**ADC Planning Consultation
Response from the Historic Buildings Adviser**

Application Number	AB/162/14/L
Address	23 King Street, Arundel, BN18 9BJ
Description	Application for listed building consent for internal alteration & enhancement/restoration works including 8 No replacement windows, 2 No replacement doors & removal of external plastic drainage pipework.
Case Officer	Anita Gardner
Site Visit	Previous

Drg 23/104

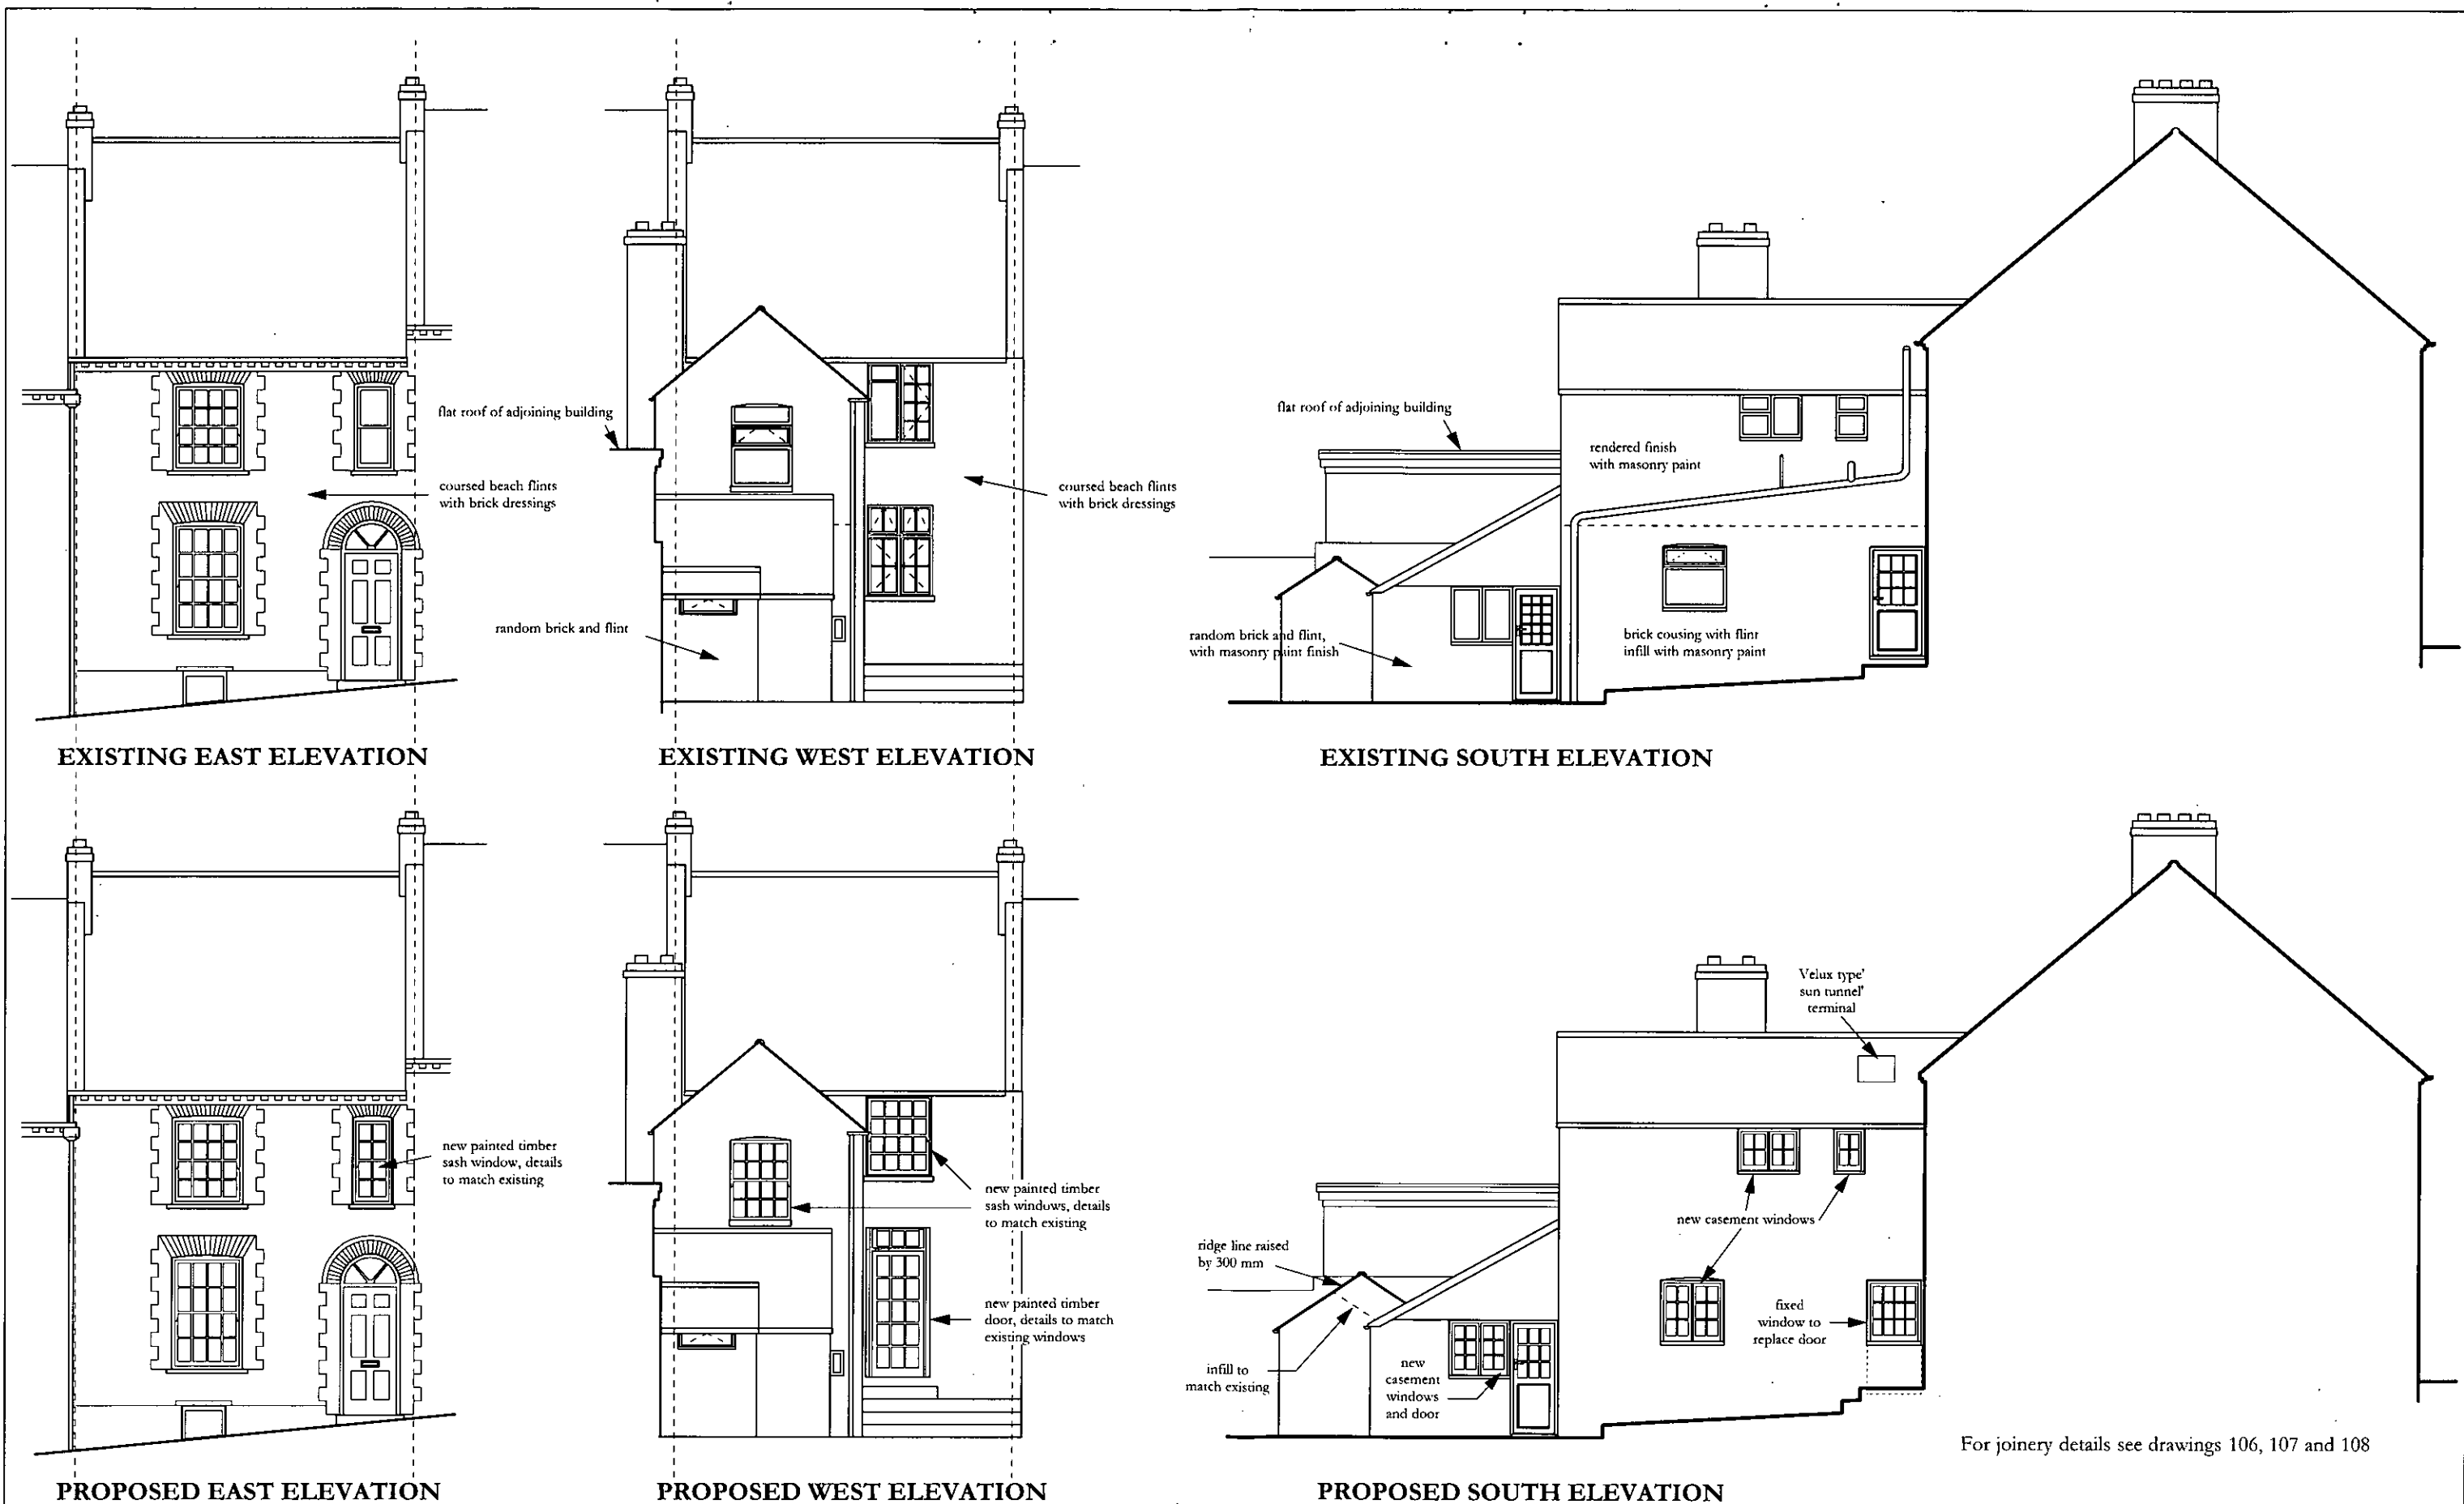
Whilst the scheme has proposed one or two interior alterations, which we previously questioned, these do not represent 'significant harm' and have largely been mitigated by a number of improvements to the fenestration. Other changes have been adhered to, including the simple surface treatment of the elevations. The additions to the rear are also maintained with a small adjustment to the roof. On balance this scheme can now be supported.
